Application No: FG/90/21/HH
Site Address: 1 Sea Drive Ferring BN12 5HD
Description of works: Erection of addition of second floor, part single, part two storey extension and wrap around terrace

Reference : Latest plans 1 Sea drive, Ferring, BN12 5HD LPA/90/21/HH

Project: Extension & Refurbishment	
for Chris Levett	
at 1 Sea Drive Ferring Worthing BN12 5HD	
Contact: Michael Austin R/BA	
E-mail: project@austinlebbon.co.uk	
Web: www.austinlebbon.co.uk	
Phone: 07958427610	
Dwg Ref: 2048 [PL] 05	Rev: A Date: September 2021

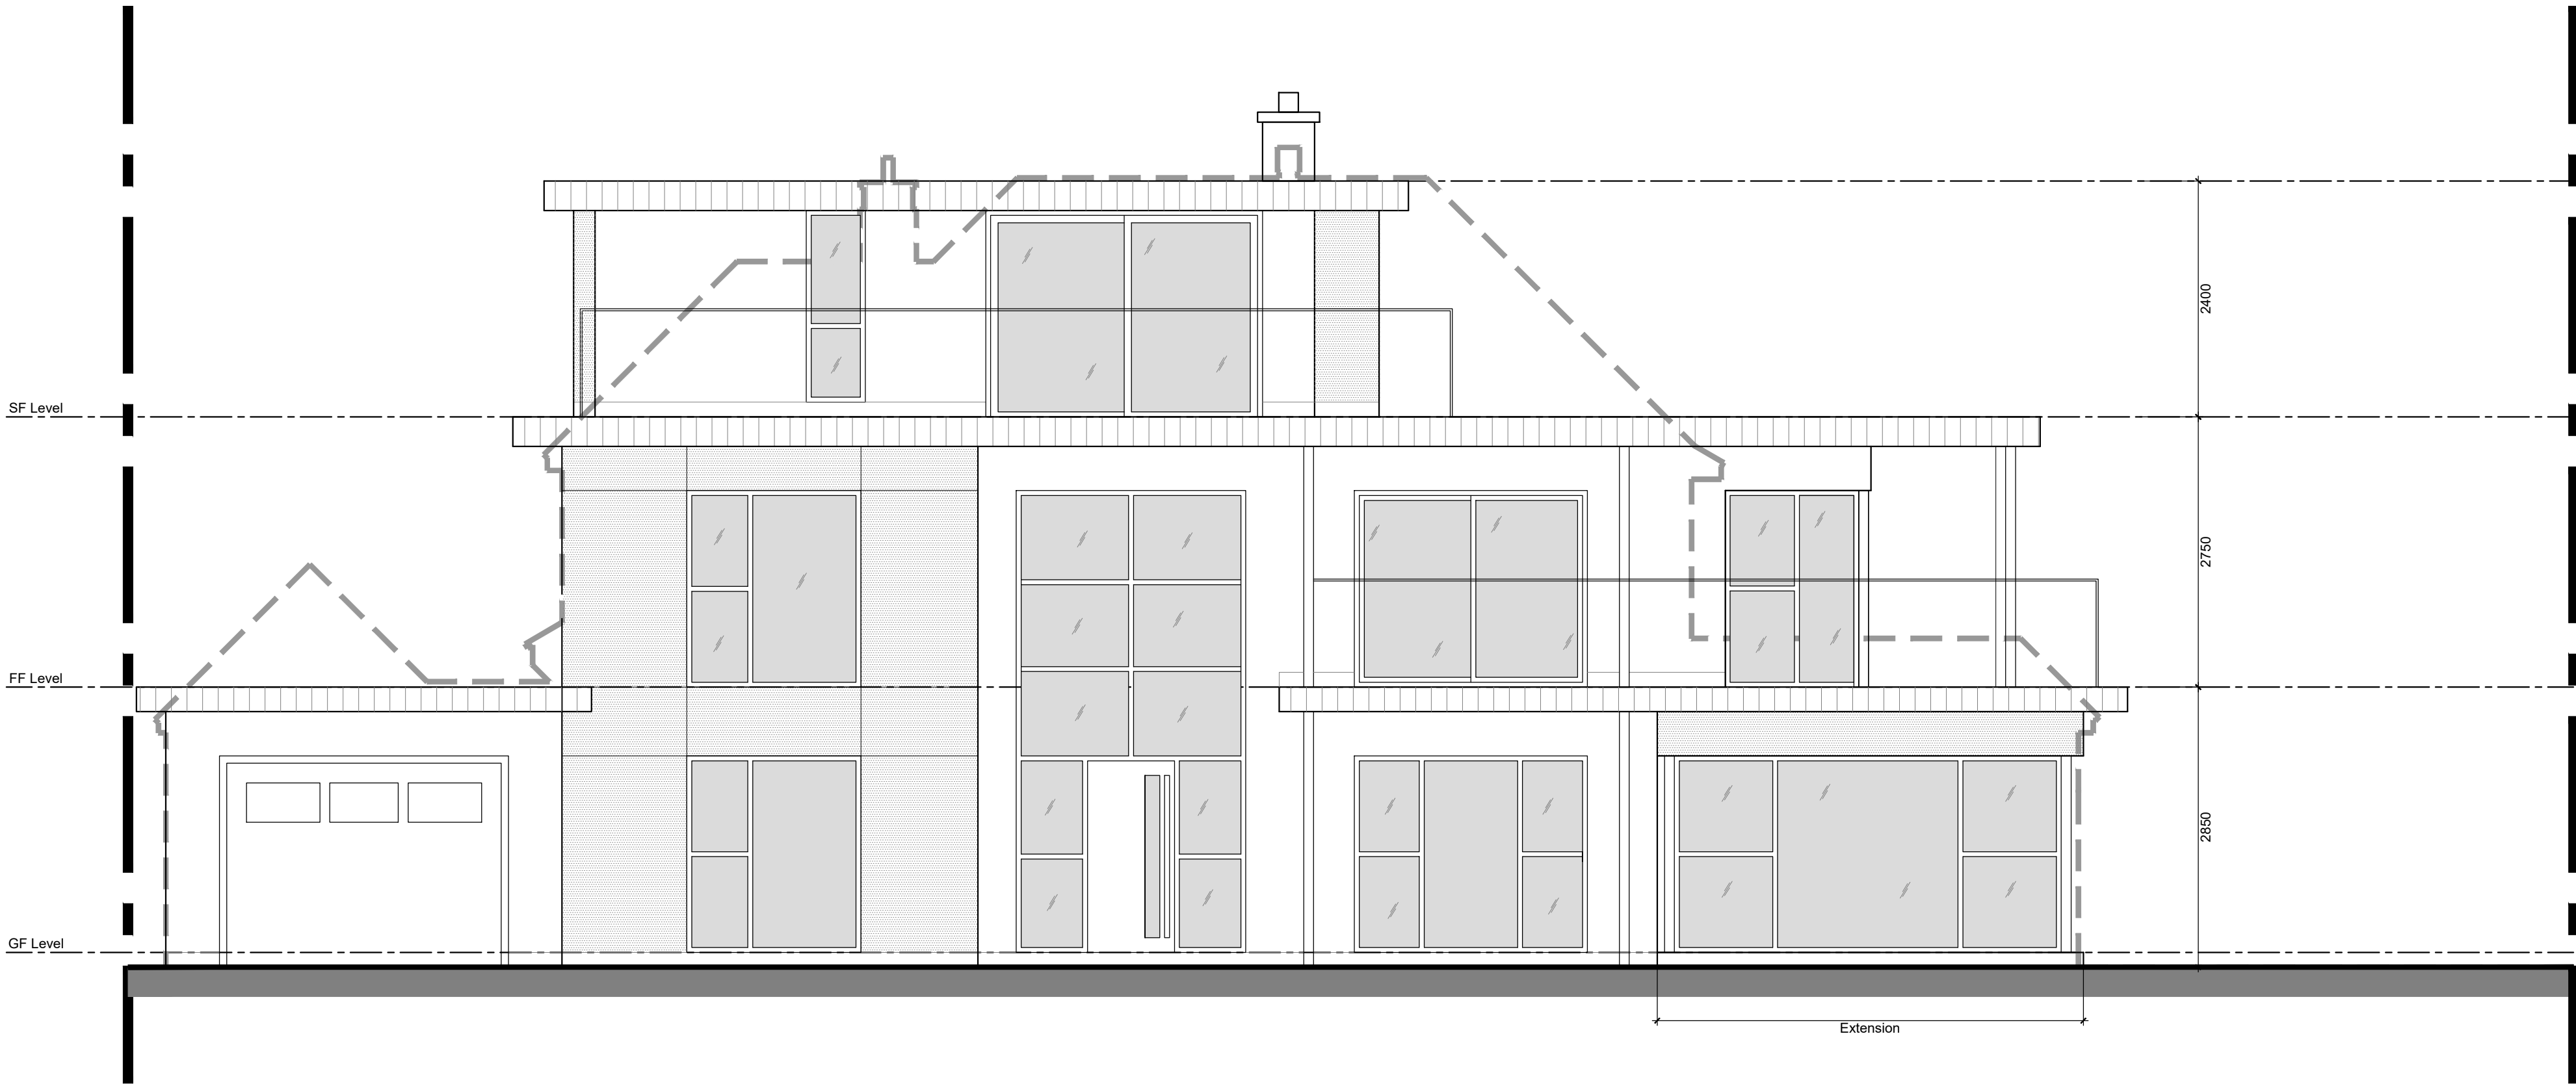
- The existing house had three small velux windows looking over to our house on the first floor, that has increased to 7 significant floor to head height windows on the new first and second floor.
- The top floor, extends outside the footprint of the original roof and is both ugly and completely unacceptable as it give 360 degree views into all of the surrounding neighbours gardens and bedroom windows. Ironically we have just been granted planning permission, but on the grounds that we needed a screen on a new balcony so we couldn't look into 1 Sea drive's garden or the property (despite being 100 feet from their property).

- The plans, both previous and recent, produce a very imposing building with excessive and unnecessary visibility into the surrounding properties when the best views are clearly to the South and East.
- We have been at pains to retain and enhance the character of our house, only to have this characterless block house complete with observation tower built next door
- As you enter Ferring from Goring Gap, this house will be your first impression of Ferring, which is not representative of the character of the village or its inhabitants

- "The proposed development will not result in any significant overbearing overshadowing impact upon the occupiers of neighbouring dwellings" I disagree, it is being changed from a chalet design to a two storey imposing building

In conclusion, despite some very minor changes to the plans, nothing has been done to address our already documented objections to the proposed building, therefore, I would ask that the plans are rejected until they are significantly altered to reduce the visual impact on the area and the invasion of privacy of both my property and those surrounding it.

Project: Extension & Refurbishment	
for Chris Levett	
at 1 Sea Drive Ferring Worthing BN12 5HD	
Contact: Michael Austin R/BA E-mail: project@austinglebbon.co.uk Web: www.austinglebbon.co.uk Phone: 07958427610	
Dwg Ref: 2048 [PL] 06	Rev: A Date: September 2021

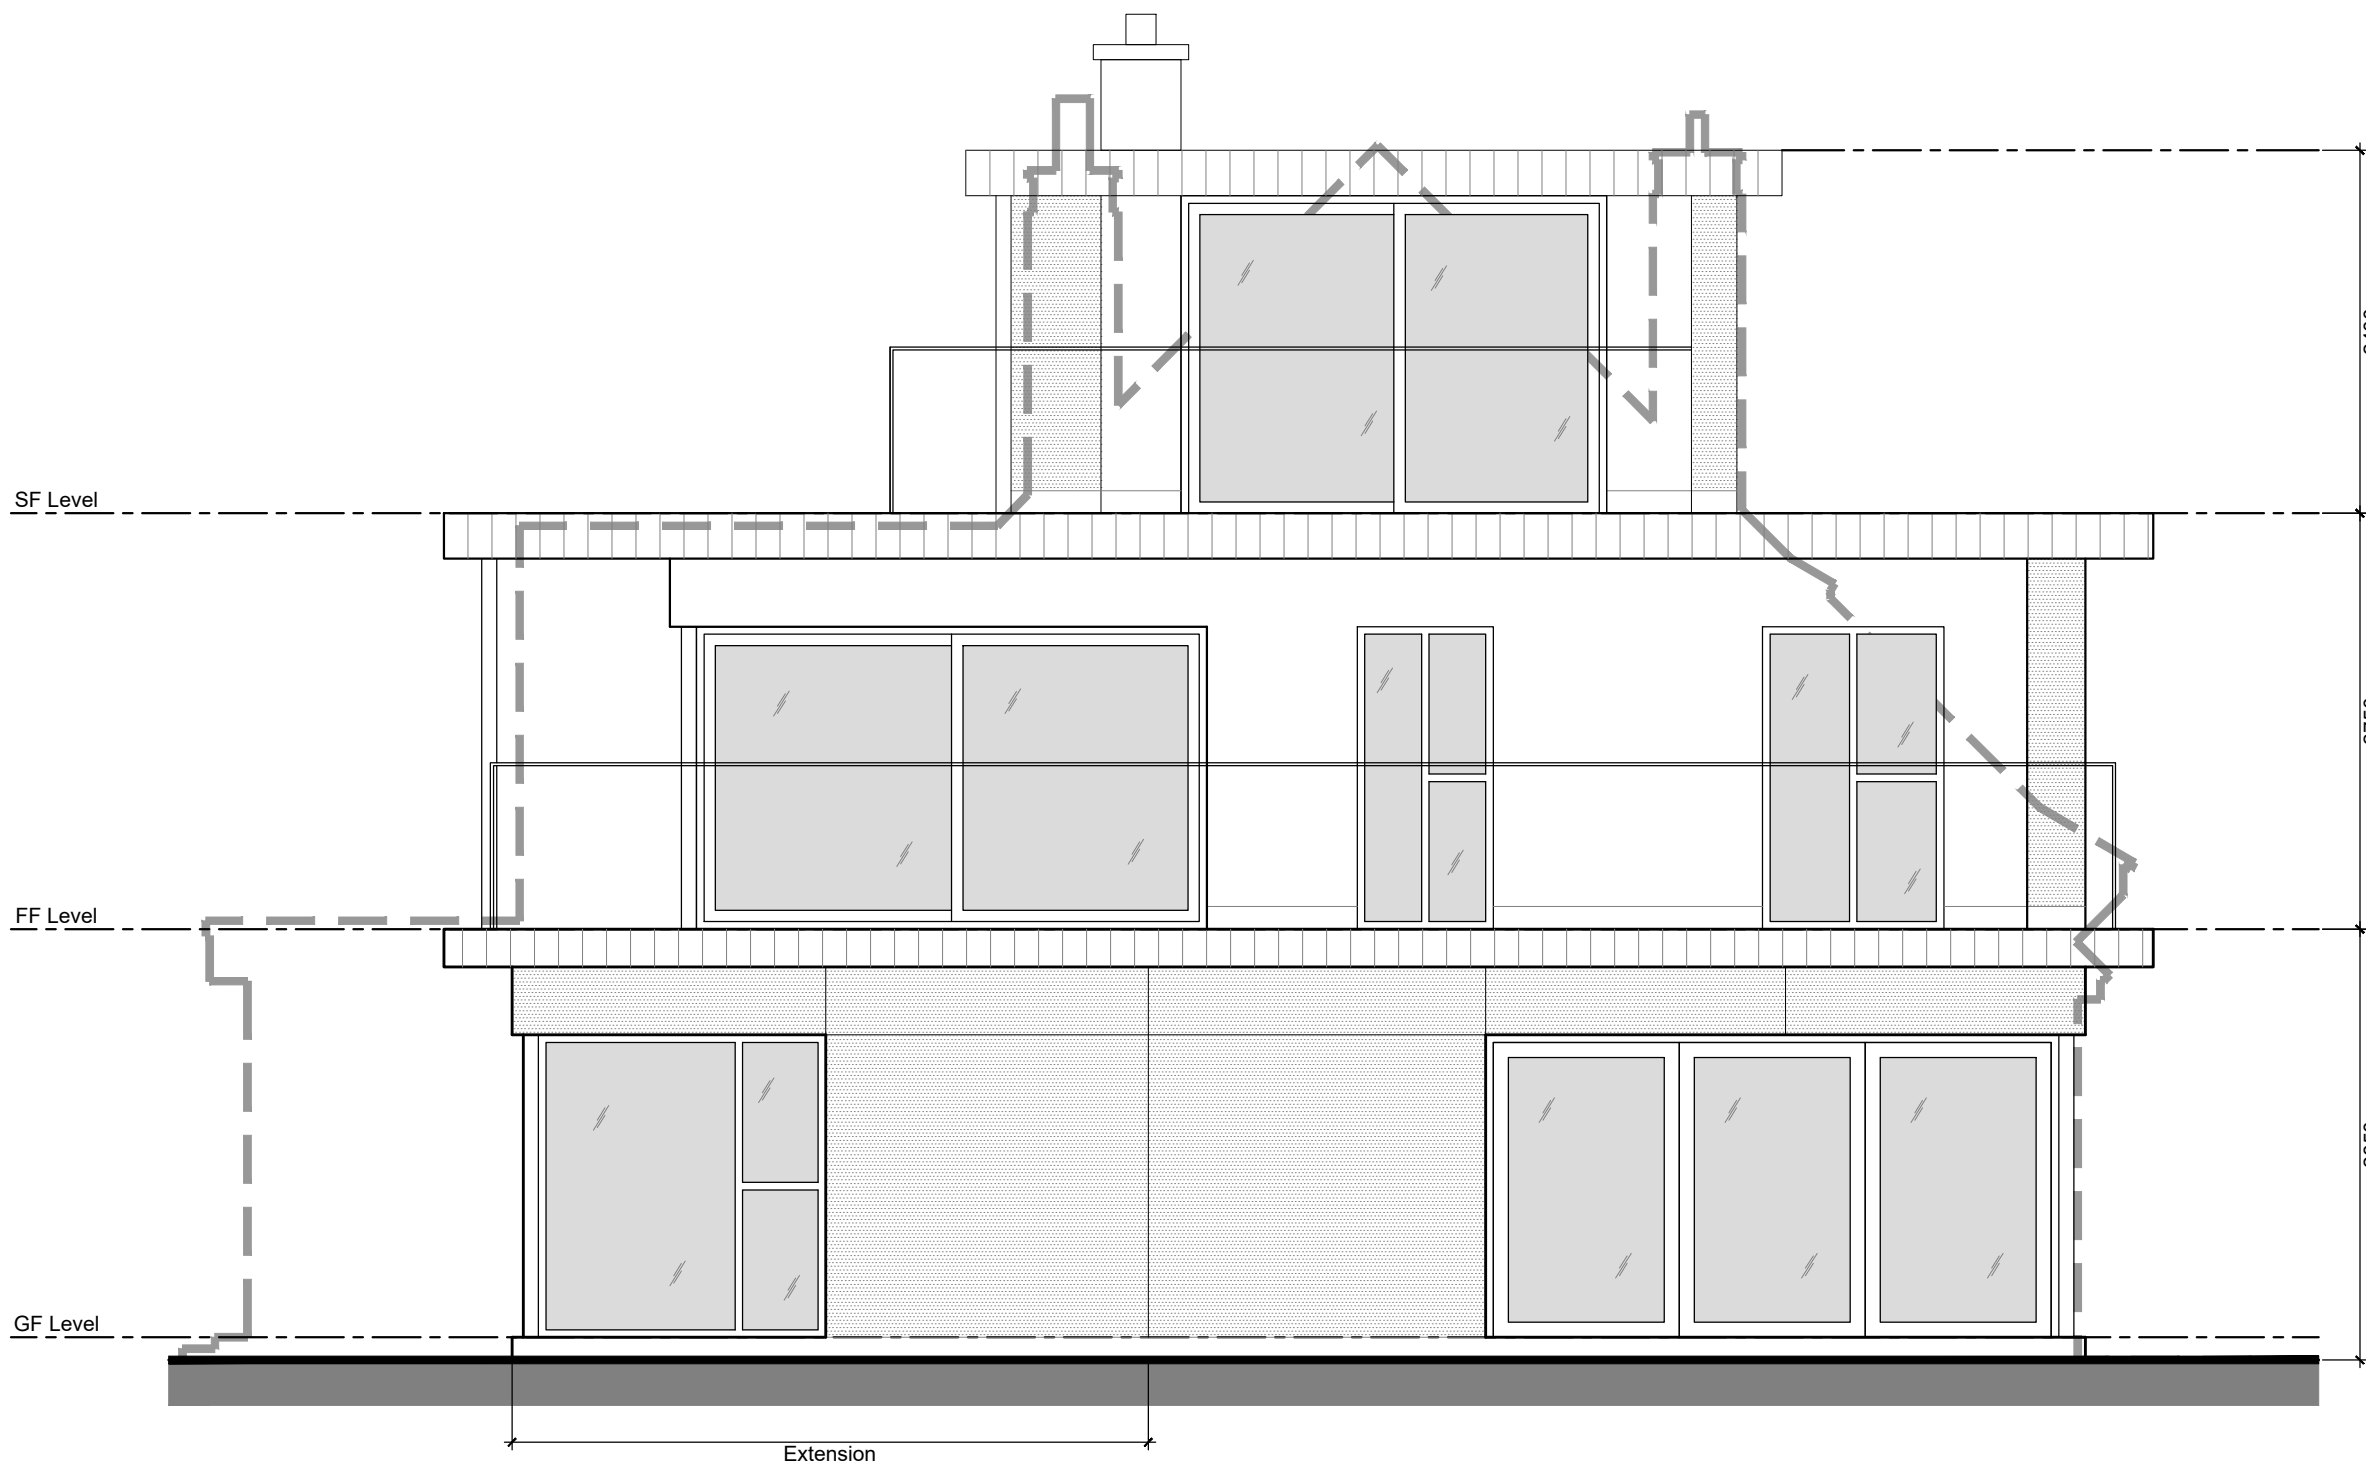
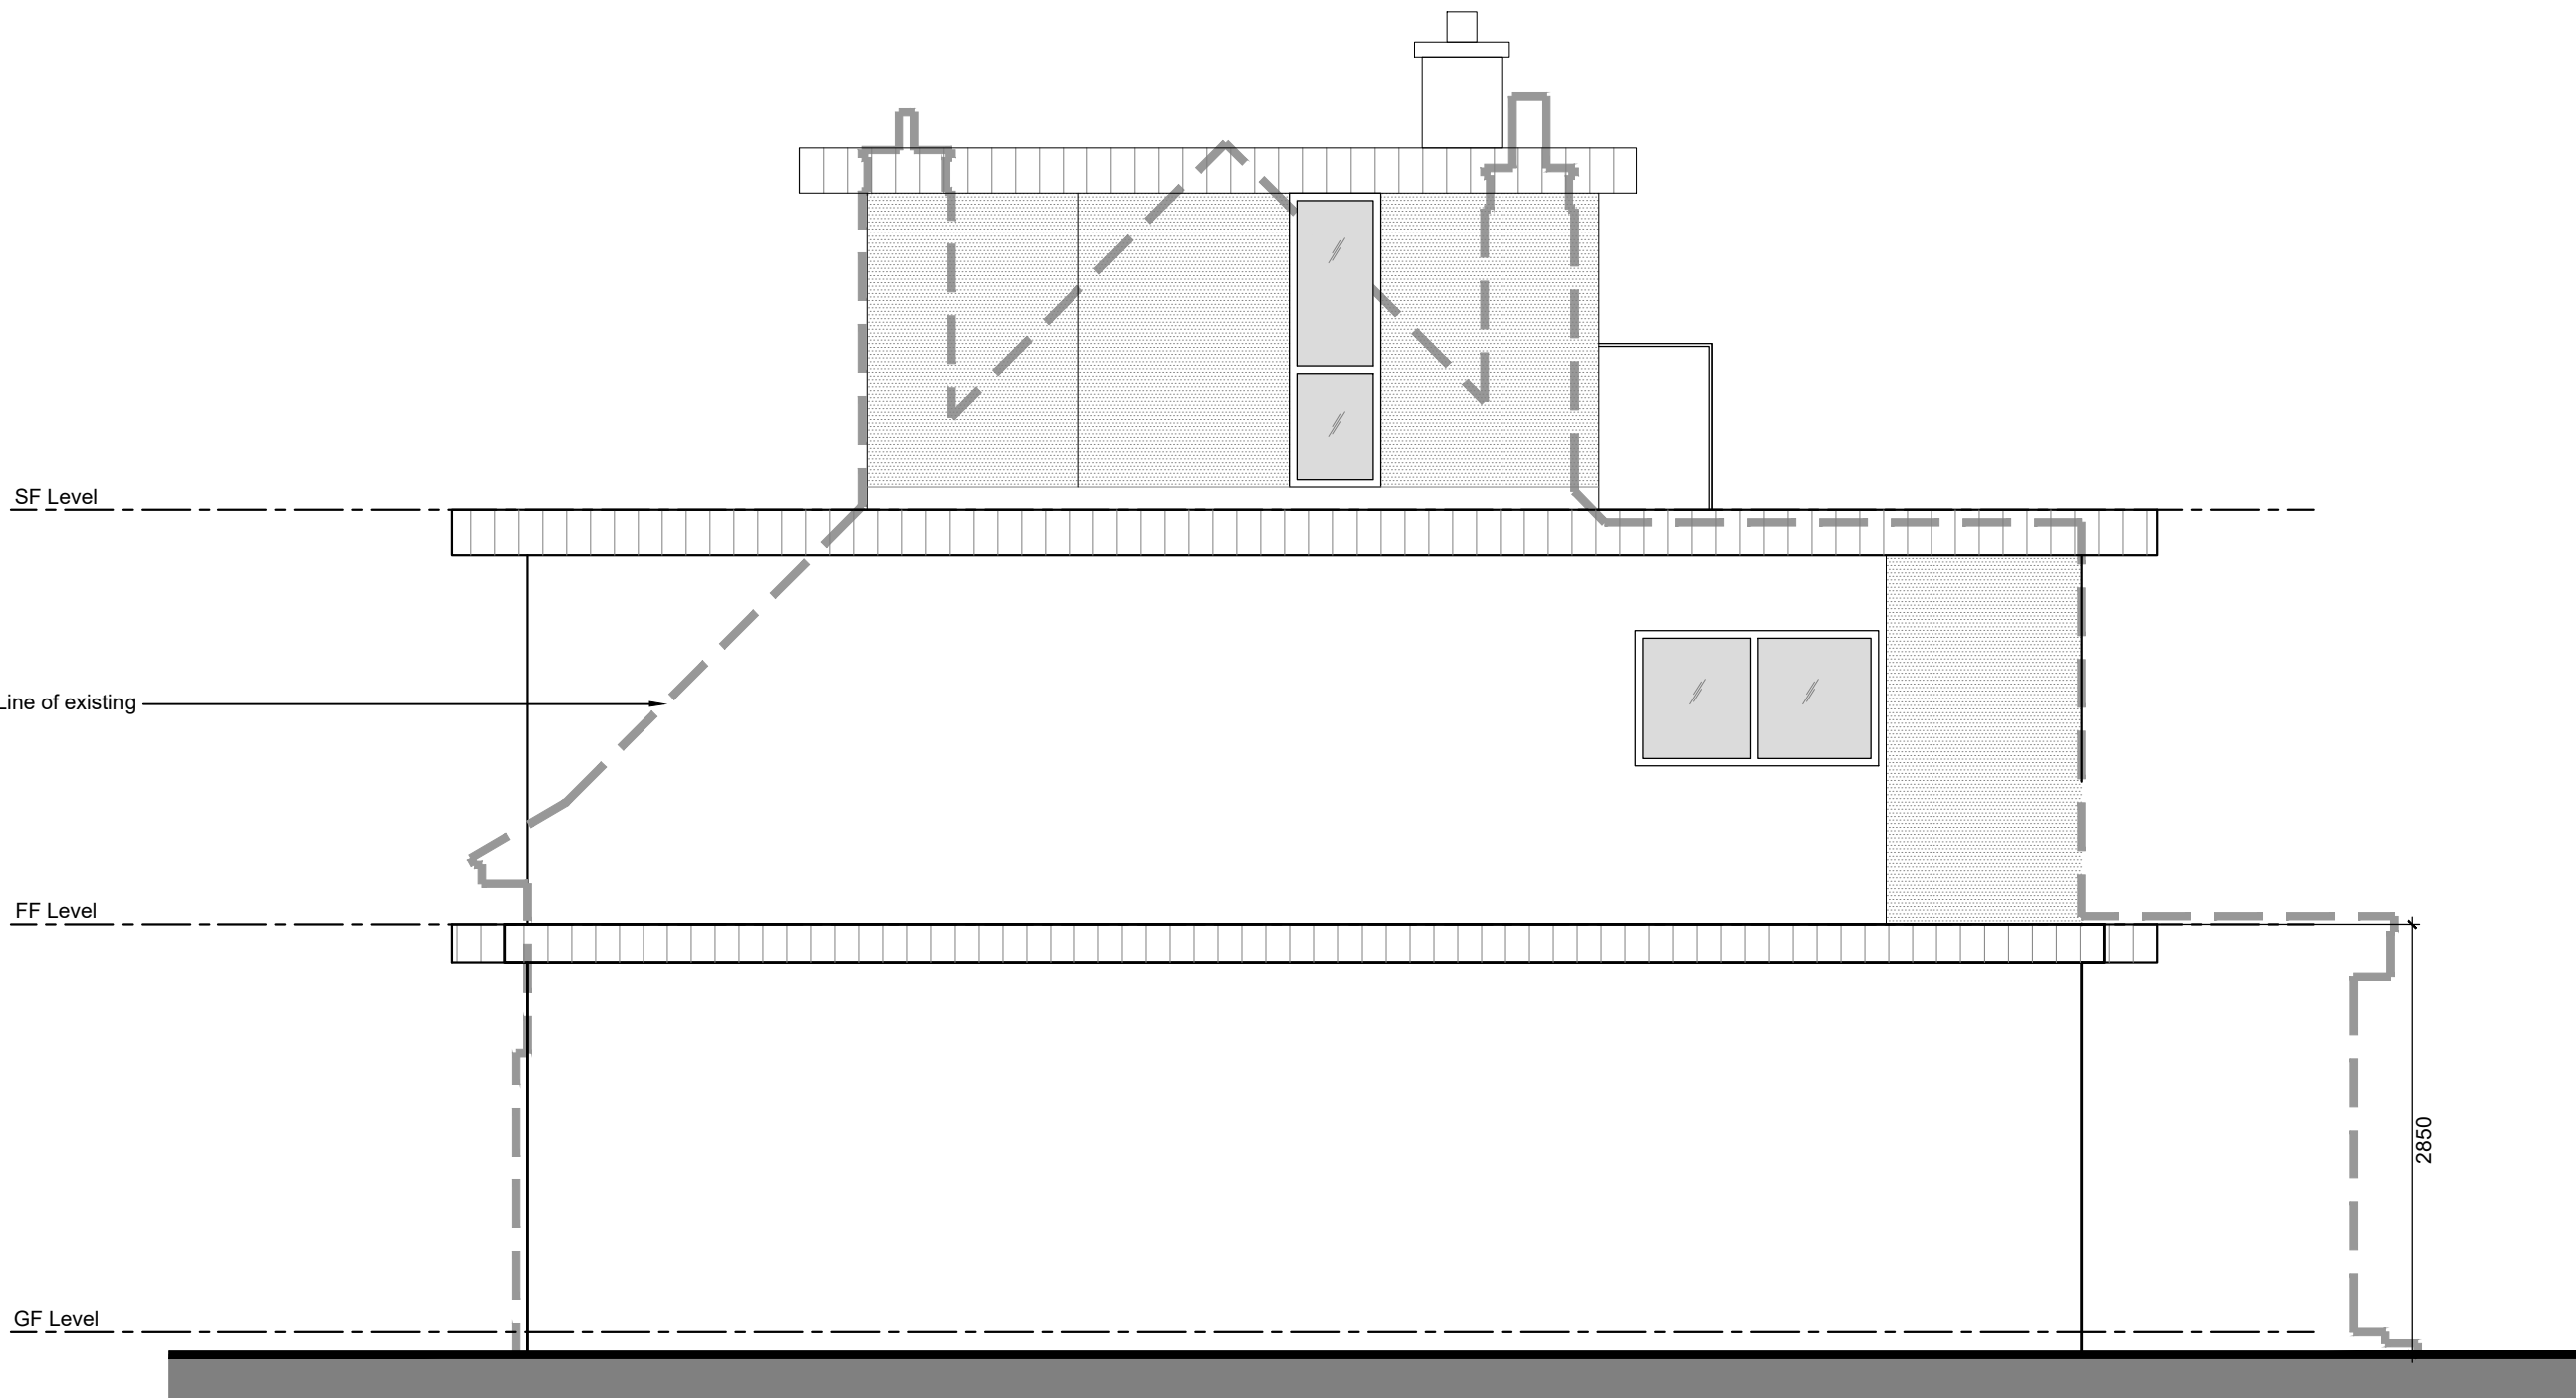
- Loss of privacy - "108 Sea Lane, sits at the end of the garden of the host dwelling approximately 27m away from the proposed windows" The planning department have insisted that I fit a screen at the end of my property in order to maintain the privacy of 1 Sea drive, therefore, the amount of extra glass on the proposed plans, should not be accepted. Also from the observation floor at the top of the building the residents will be able to look straight into my bedroom window and my back garden, along with our close neighbours so invading our privacy, this is totally unacceptable.
